RE: Blue Sky Short Plat (SP-10-00003)

The Kittitas County Community Development Services Department has determined that the Blue Sky Short Plat (SP-10-00003) is a complete application and hereby grants *conditional preliminary approval* subject to the following conditions:

BLUE SKY SHORT PLAT
A PORTION OF THE SOUTH 1/2 OF SEC. 29 T.20N., R.16E., W.M.
KITITAS COUNTY, WASHINGTON

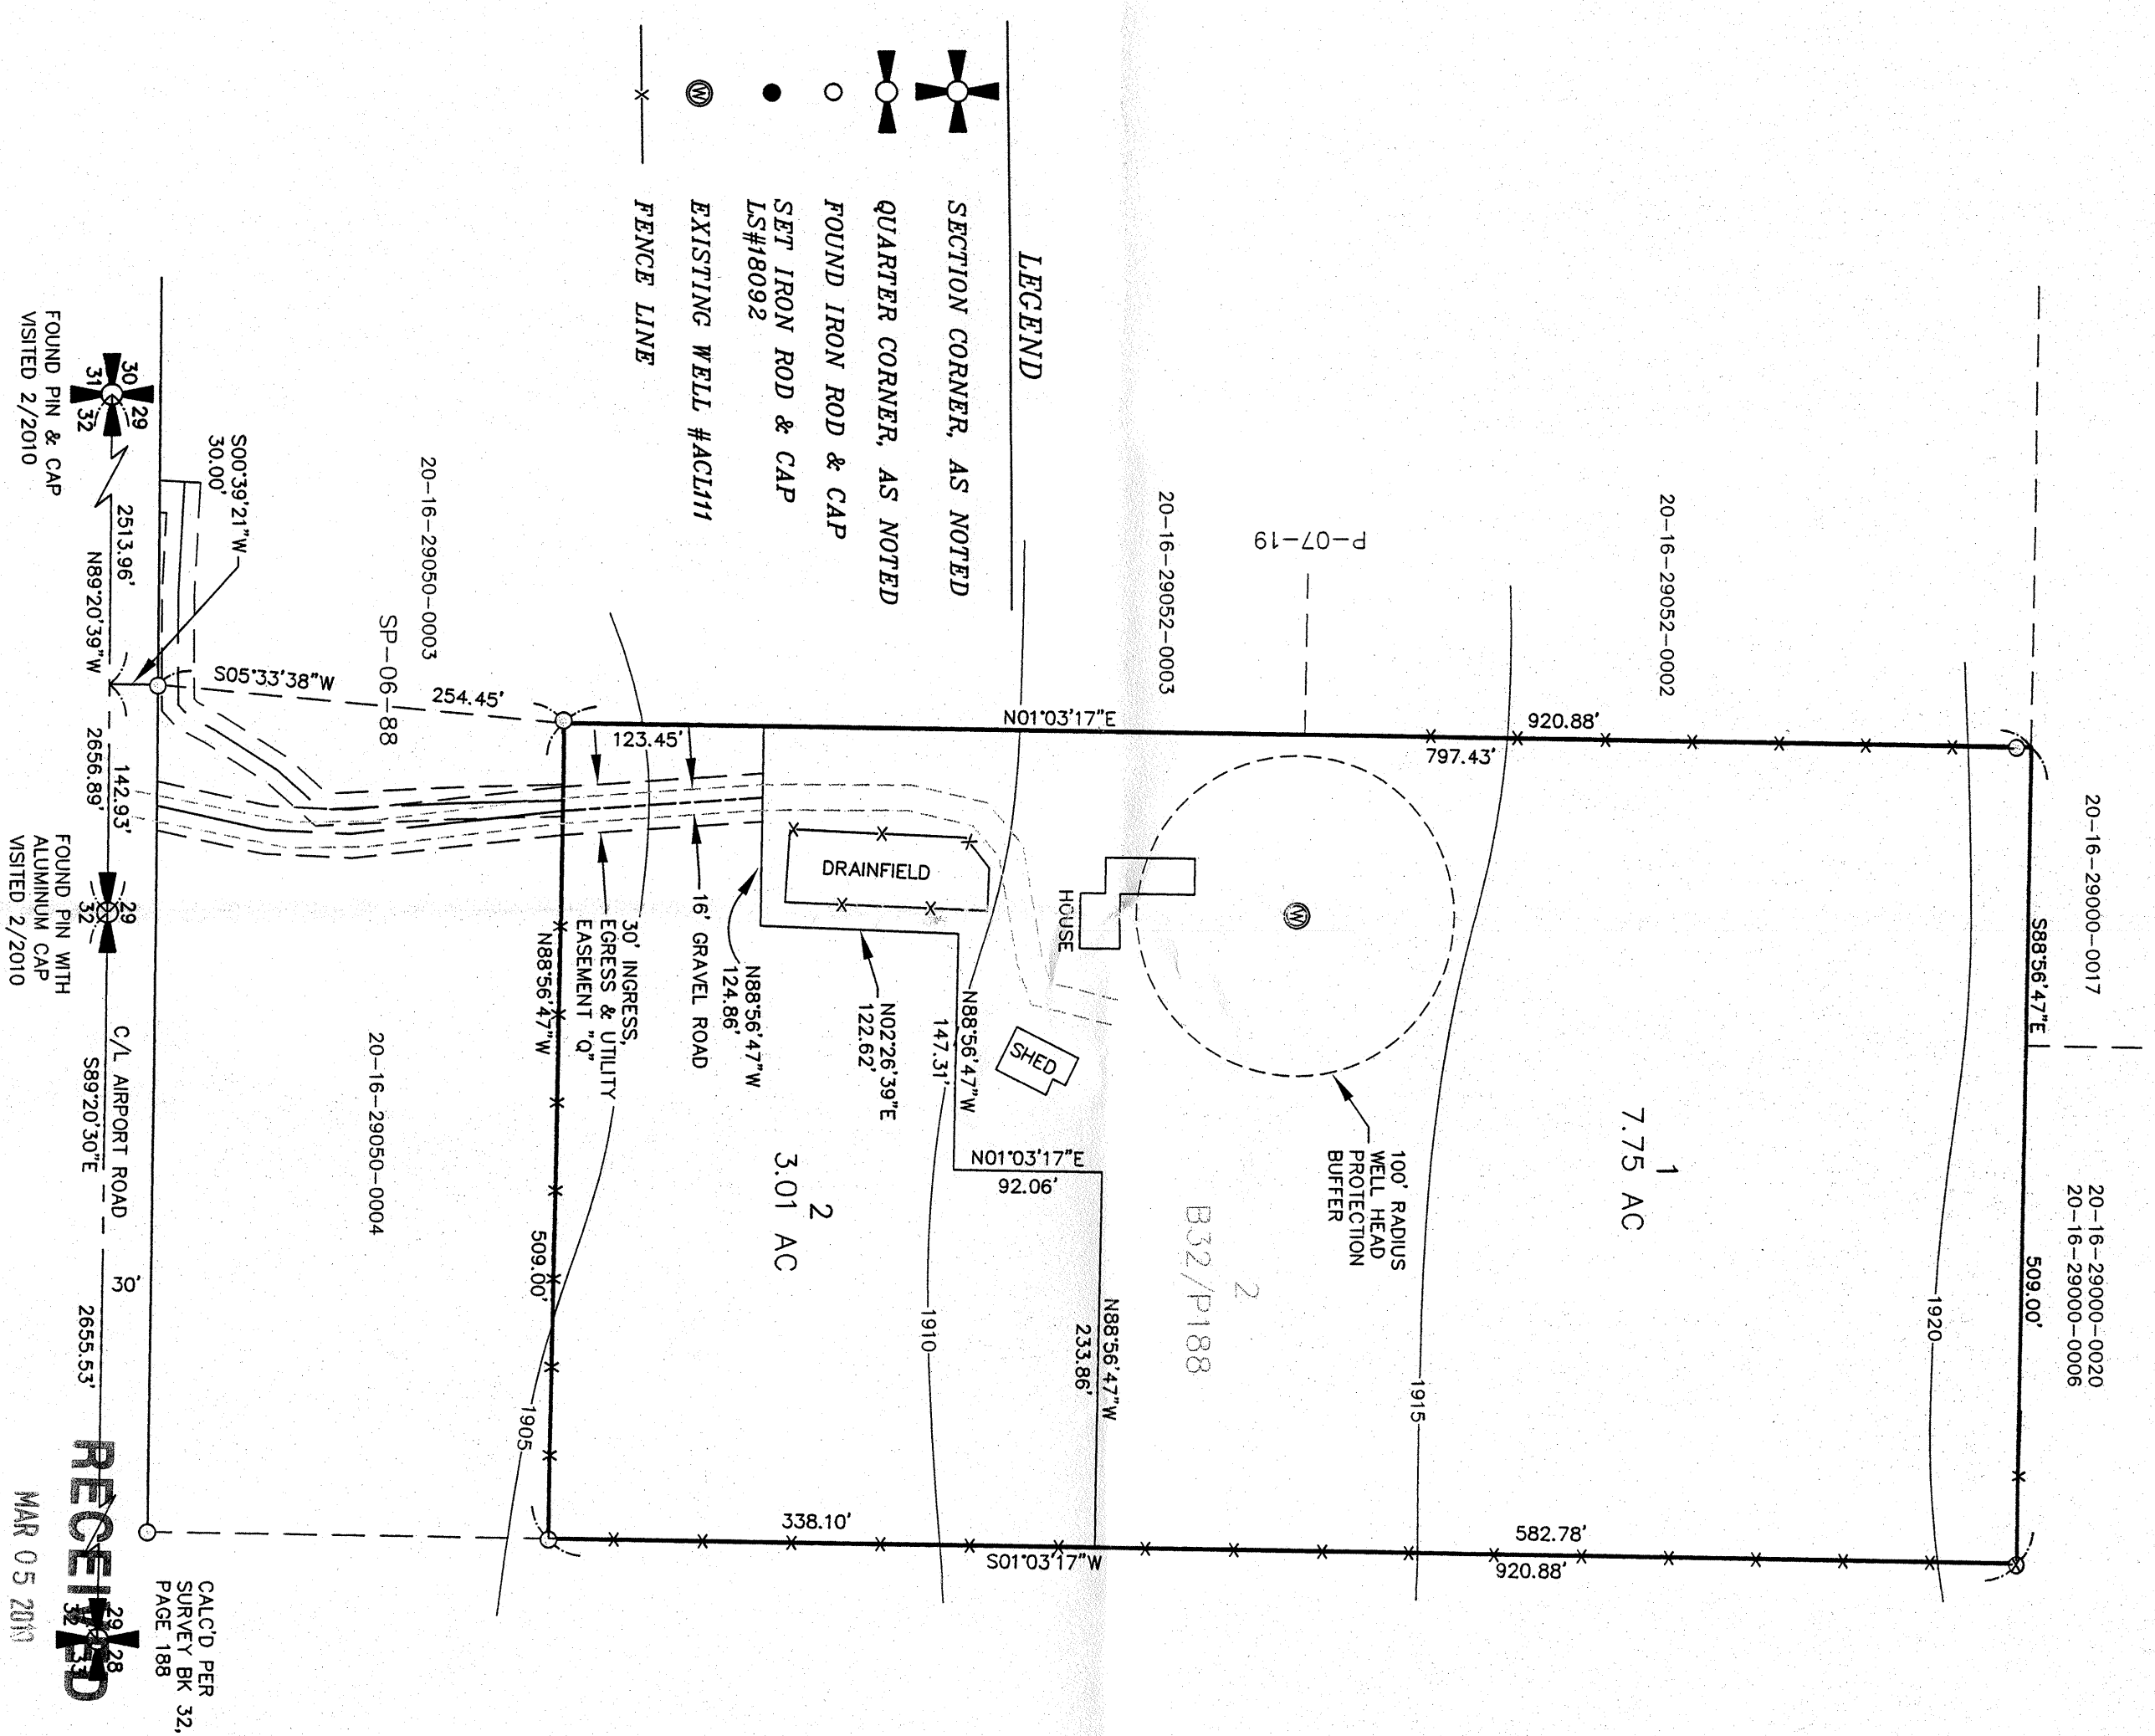
1. Both sheets of the final mylars shall reflect short plat number SP-10-00003 and an accurate legal description shall be shown on the face of the final plat.

4. Individual wells are required to have a 50 foot setback from neighboring property lines (KCC 17A.08.025).
5. Should ground disturbing or other activities related to the proposed short plat result in the inadvertent discovery of cultural or archaeological materials, work shall be stopped in the immediate area and contact be made with the Washington State DAHP. Work shall remain suspended until the find is assessed and appropriate consultation is conducted. Should human remains be inadvertently discovered, as dictated by Washington State RCW 27.44.055, work shall be immediately halted in the area and contact made with the coroner and local law enforcement in the most expeditious manner possible.

8. The addresses shall be clearly visible from both directions at the County Road for all properties.
9. The Fire Department access road shall be capable of supporting 75,000 lbs in all weather, be 20' wide, provide 13'6" vertical clearance and provide for adequate turn-around for fire department apparatus.
